Appeal Decision

Appeal Ref: APP/R5510/D/25/3361233

49 Falling Lane, Yiewsley, Middlesex UB7 8AB

- The appeal is made under section 78 of the Town and Country Planning Act 1990 against a refusal to grant planning permission.
- The appeal is made by Mukesh Chhaya against the decision of the Council of the London Borough of Hillingdon.
- The application Ref is 16917/APP/2024/2747.
- The development proposed is the erection of a single storey conservatory to the rear.

PROPOSED GROUND FLOOR PLAN

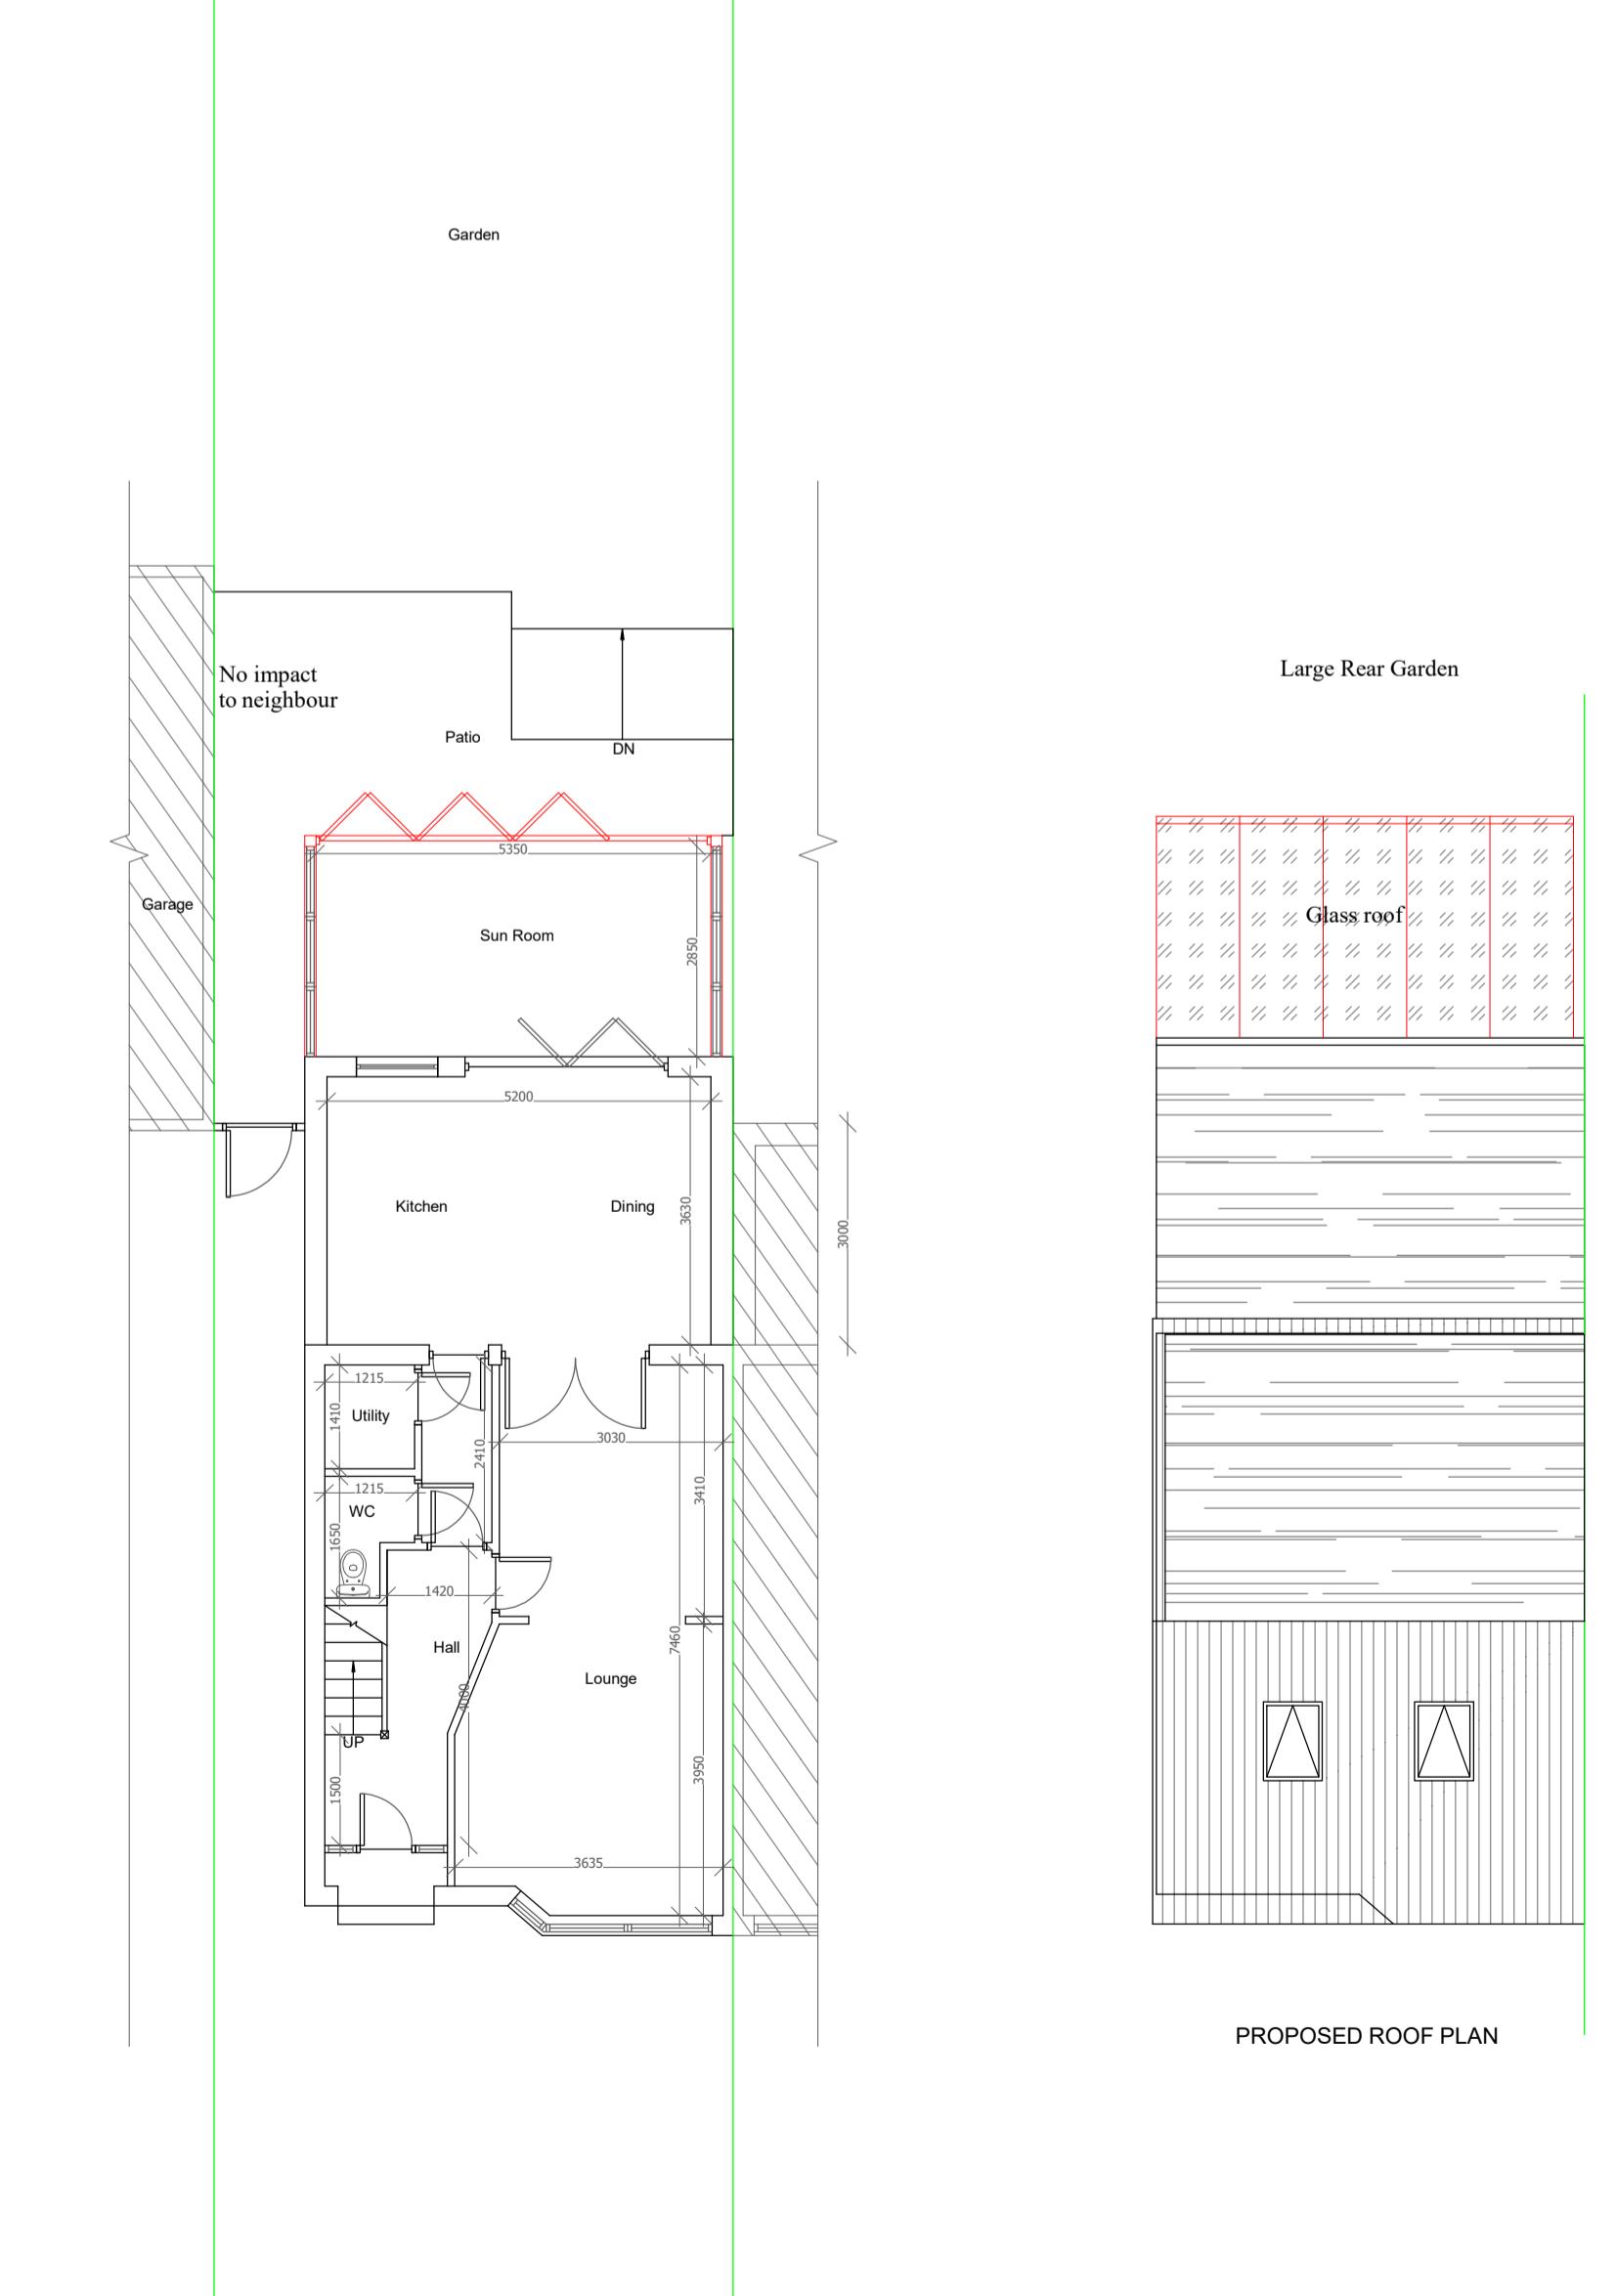
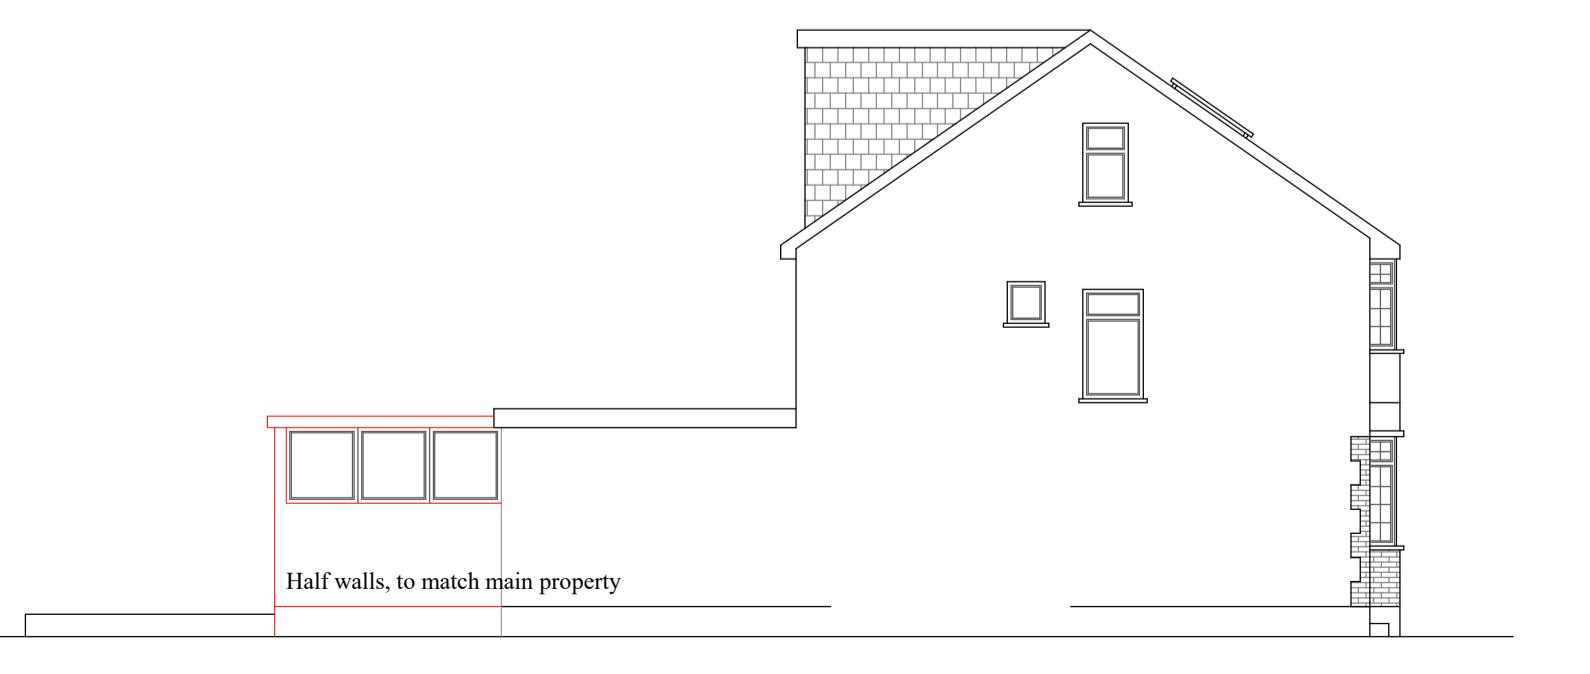
8. The Council is concerned that the scheme would impinge upon privacy currently enjoyed by the neighbours to the north. This is because the conservatory is shown to have side boundary windows from which one could look across onto the neighbours' patio and backwards into rear windows.
9. I would agree that there would be a privacy issue if the conservatory was to be constructed in the form envisaged by the Council. However, as the Appellant rightly suggests, the solution to this would be obscure glazed and non-opening windows. A condition to this effect would, to my mind, be legitimate,

11. The Council is concerned that direct and short distance views would be provided from the rear garden and patio area of No.51 Falling Lane into the proposed sun room leading to a harmful loss of privacy to users of the room at this host property.

1. The appeal is allowed and planning permission is granted for the erection of a single storey conservatory to the rear at 49 Falling Lane, Yiewsley, Middlesex UB7 8AB in accordance with the terms of the application, Ref 16917/APP/2024/2747, subject to the following conditions:
 1. The development hereby permitted shall begin not later than three years from the date of this decision.
 2. The development hereby permitted shall be carried out in accordance with the following approved plans: Location Plan & Drawing 49-001.
 3. Notwithstanding the above condition 2 the conservatory hereby permitted shall not be occupied until all windows on the northern side have been fitted with obscured glazing with fixed panes and these shall be retained thereafter.

14. The scheme should have the standard commencement condition. I agree with the Council that there should be a condition that works are to be carried out in accordance with listed, approved, plans; to provide certainty. As noted above, I agree with the Appellant that it would be prudent for windows on the northern elevation to be obscure glazed and fixed in order to protect the privacy of immediate neighbours and future occupiers.
